From: Martyn White
Sent: 13 December 2018 15:52
To: Planning.Responses
Cc: Richard Castro-Parker
Subject: BN/38/18/L

BN/38/18/L

The proposed works comprise the erection of an oak framed extension to the rear facing elevation of the building and would be of timber construction. The application property is a detached Grade II listed building within a mature garden area.

Proposed

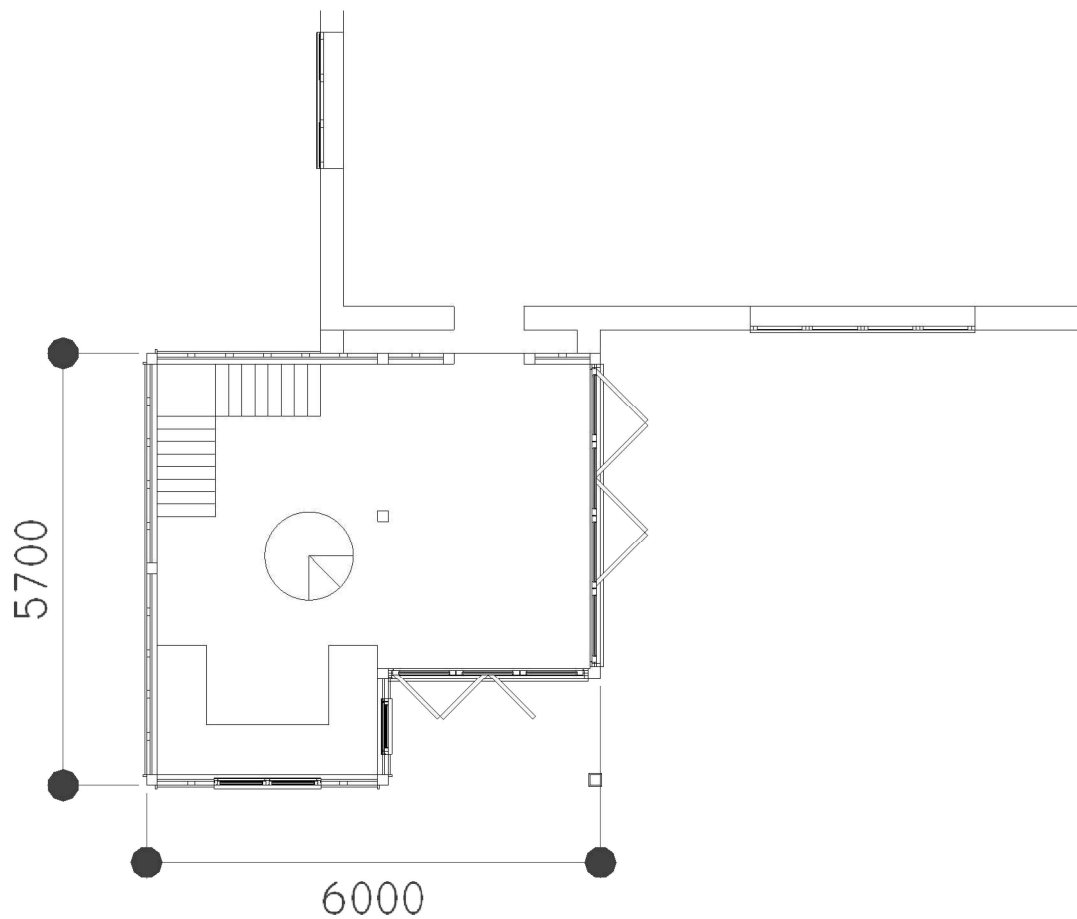
The current proposal appears as an afterthought; that is to say as if it has been tacked on to the corner of the existing building. In addition, the extension is taller than the part of the listed building it adjoins. The location/position of the extension is therefore problematic, and should be amended so as to better fit with the host dwelling.

The floor plan of the extension is irregular in shape which creates a covered porch area. An extension such as this one should be simply treated so as to not dominate the general character of the building.

I note that the use of timber as a building material has previously been approved, and that it is proposed to be used again. As a consequence such a material can be used as part of this scheme. Neighbouring windows are multi paned and this element could be reflected in the new windows (via discharge of condition if the application is approved).
